SF19014-R2-Plat-Redlines Summary_Markup Summary

ENG-SF19014-R2-TIS-Redlines Summary_Markup Summary

ENG-SF19014-R2-MDDP-Redlines Summary_Markup Summary

# FINAL PLAT

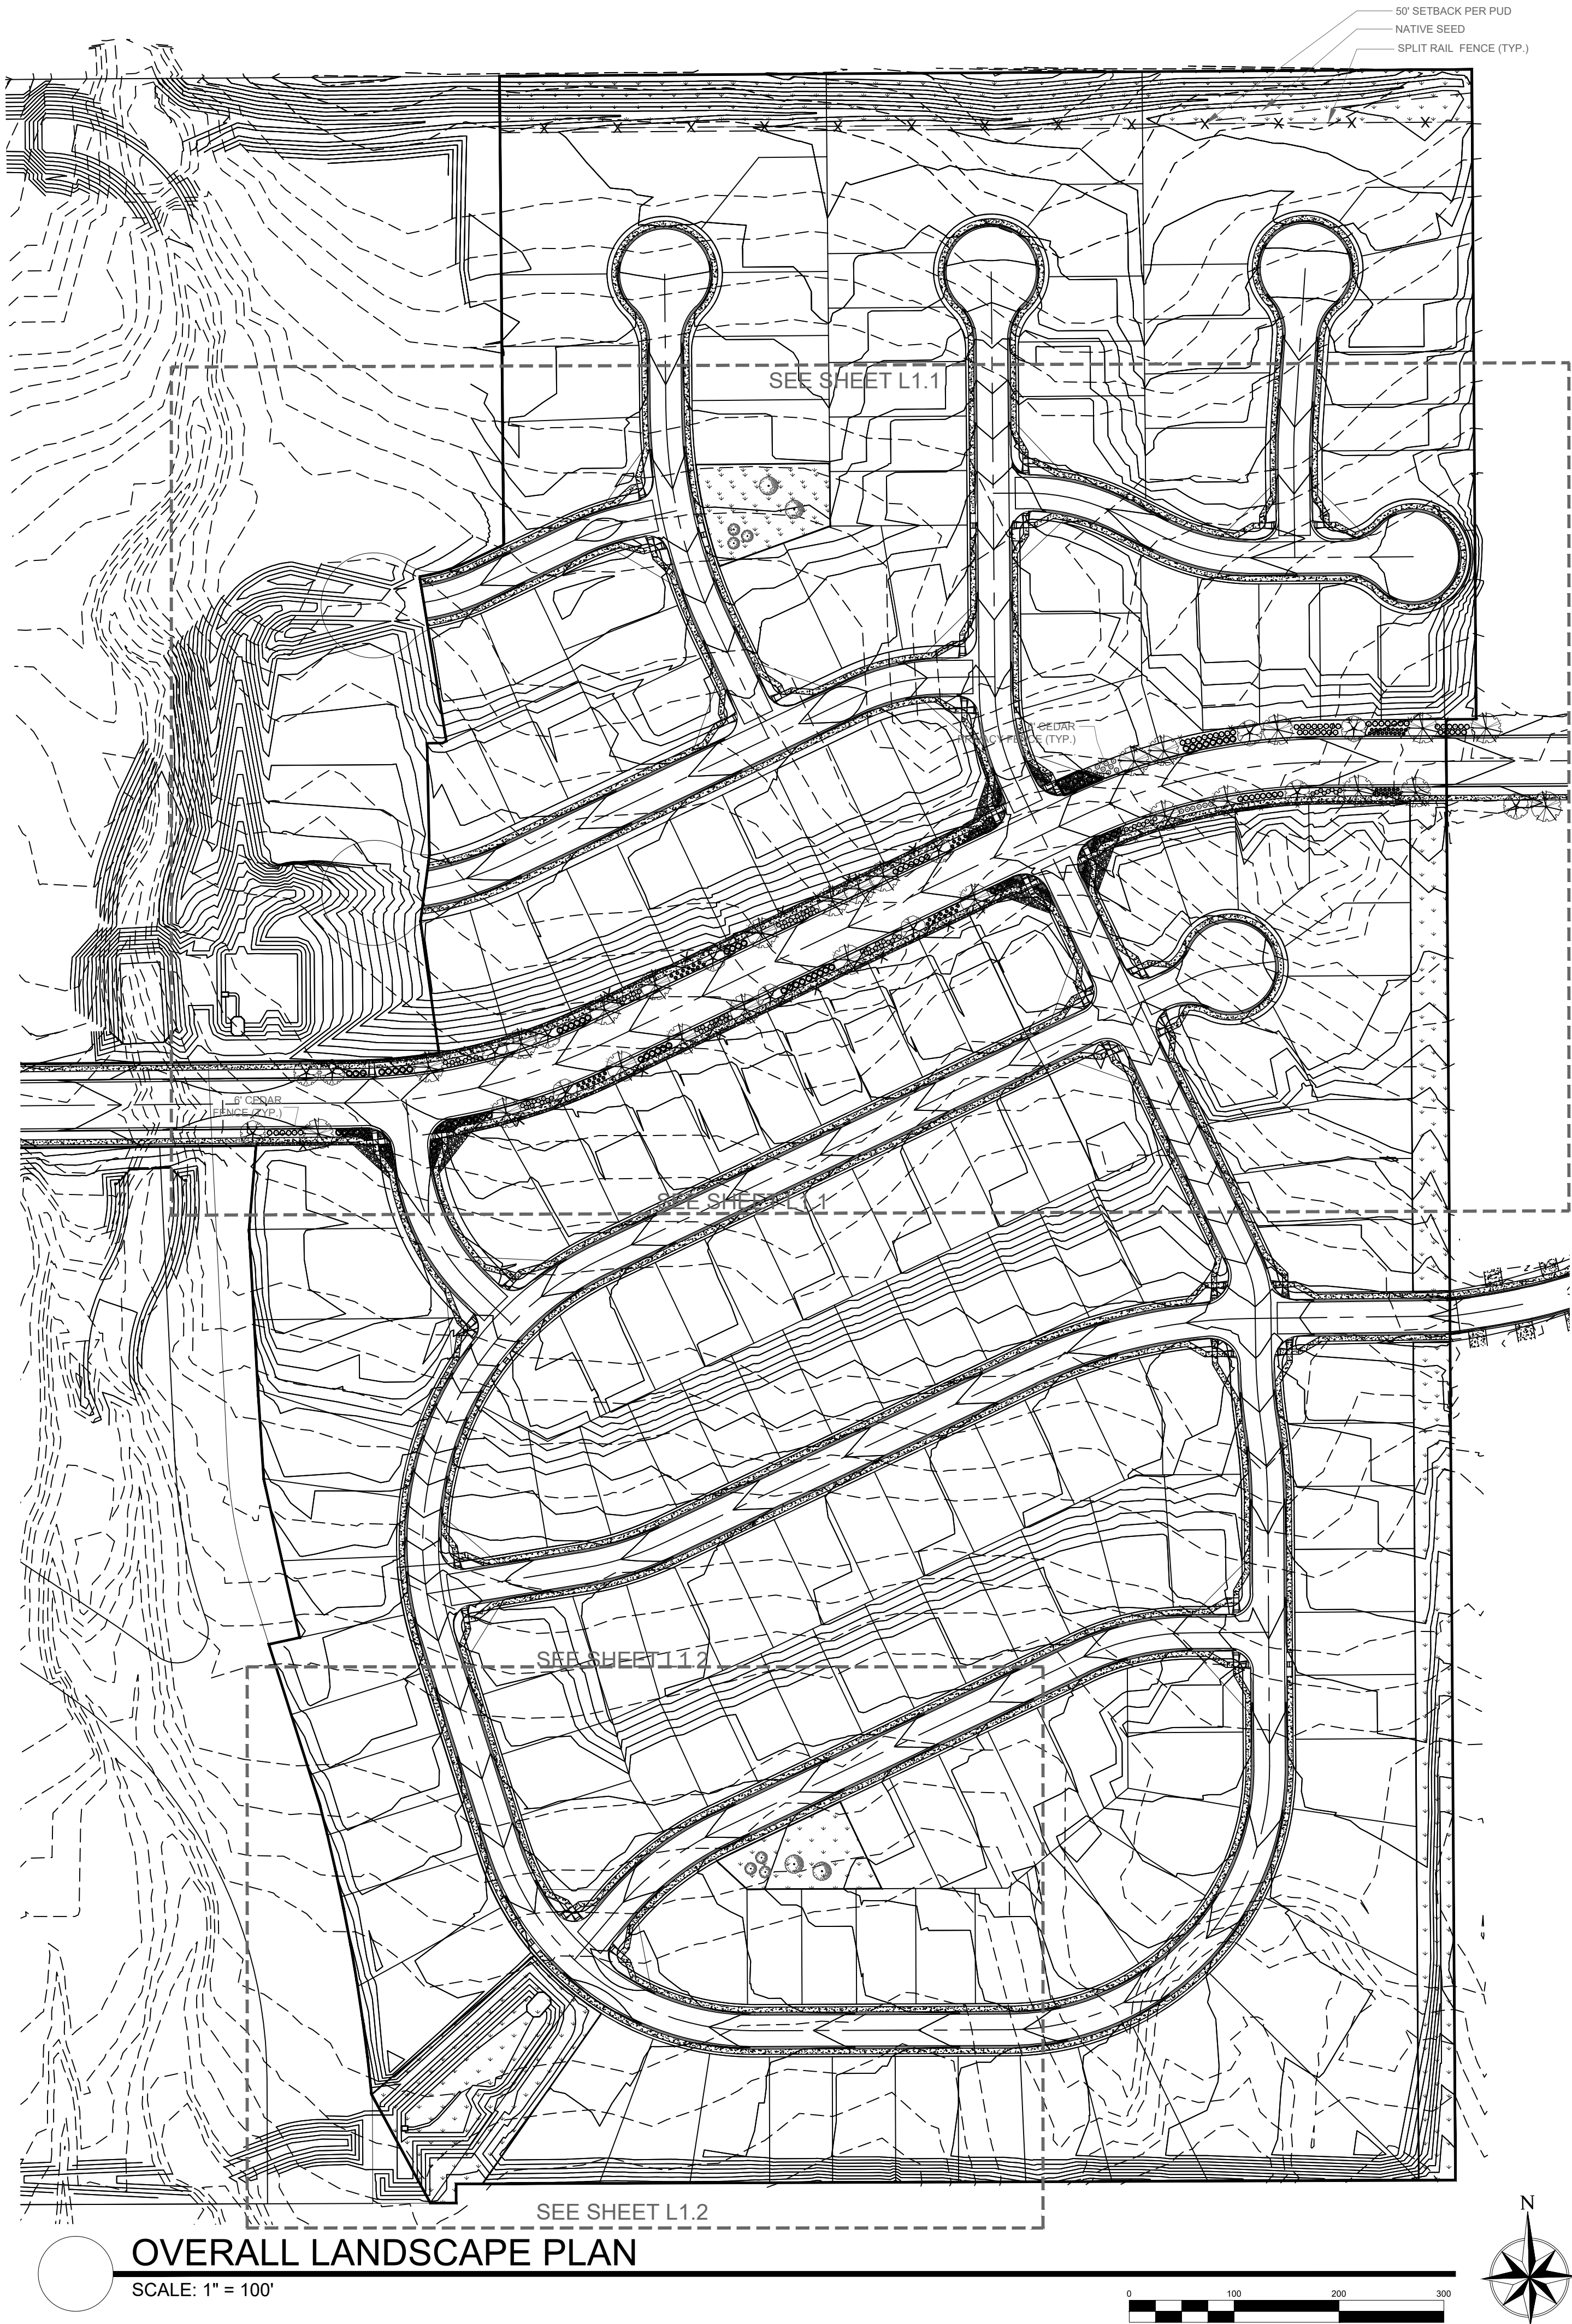
The drainage needs to be in tract- its to be maintained by ____ and the drainage tract will not be developed in the future but the other land adjacent will be - label remaining future development tract outside of the drainage tract. trail connectivity through drainage tract. This is the final plat, all easements, trails drainage ways, open space tracts must be depicted. Plat the drainage in a tract and that will increase the open space

Plat the lots and cul de sac here - Why would you leave empty space and come back in later to plat-Channel improvements whether stabilization or CLOMR must be addressed with the plat's drainage reprot.

put the floodplain in a trct by itself- show the required elevations

isnt there a large drainage easement here along the nrth heading west? State who is going to maintain this offsite easement if your not platting as a tract with this plat

finish road and lot lines or culdesac this? lots may be more efficeint

is there a pond here? are you keeping?

We discussed putting a trail accross here- this would tie in to the development to the west.
